275 Cumberworth Lane
Denby Dale
Huddersfield
HD8 8PT

22 August 2022

**Proposed Development at Cliff Hill Site Denby Dale off Cumberworth Lane.
Planning Application 2022/91911**

Proposed Section 4-4
Scale 1 : 100

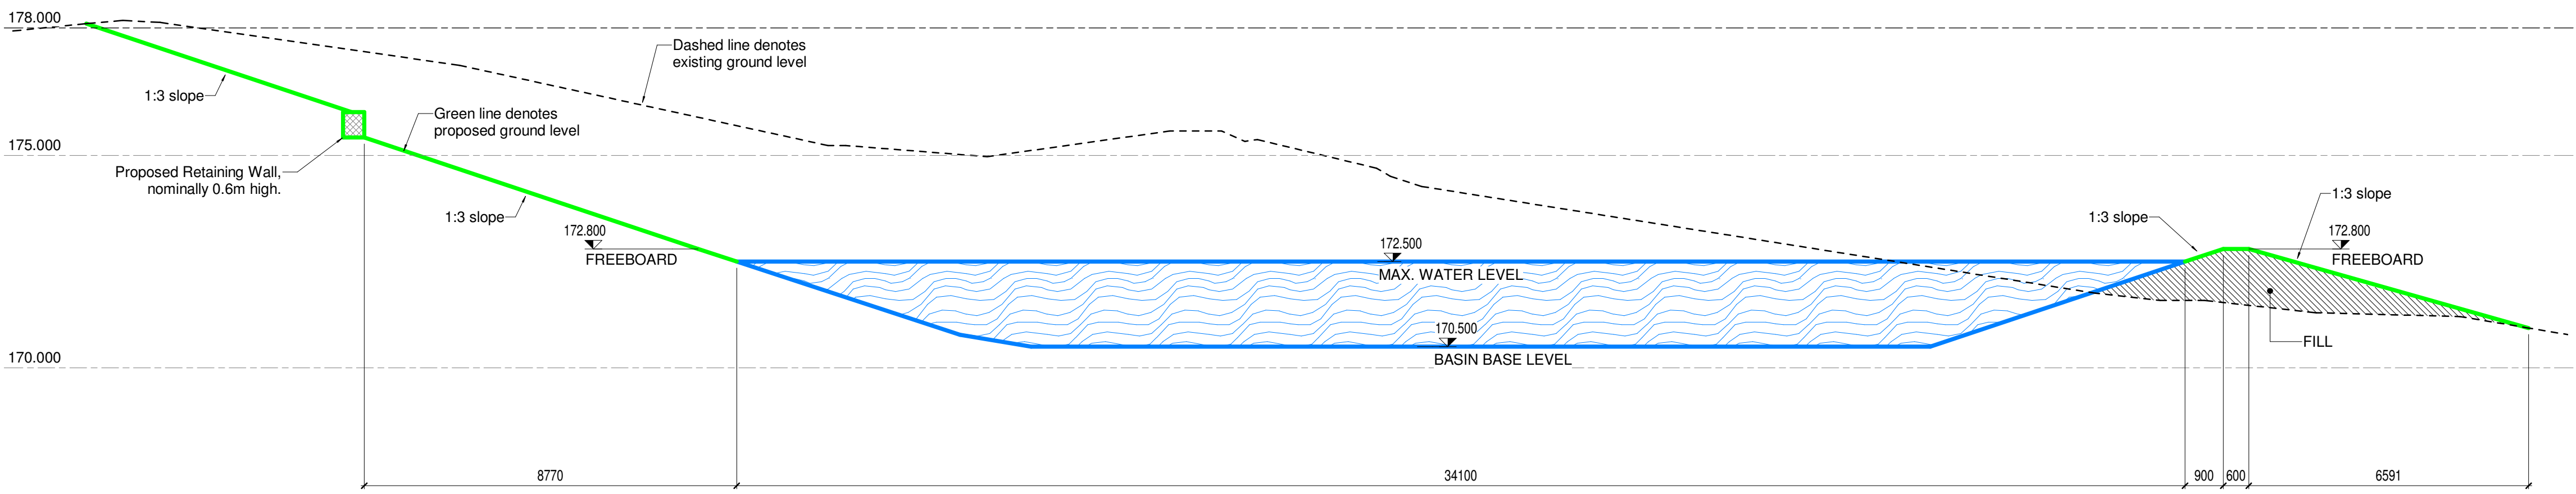
3. The proposal involves significant open cast mine workings to remove a coal seam approximately 1.4m deep. The excavation, compaction and associated vibration is likely to damage the existing surrounding properties. How will you the developer negate this risk ?
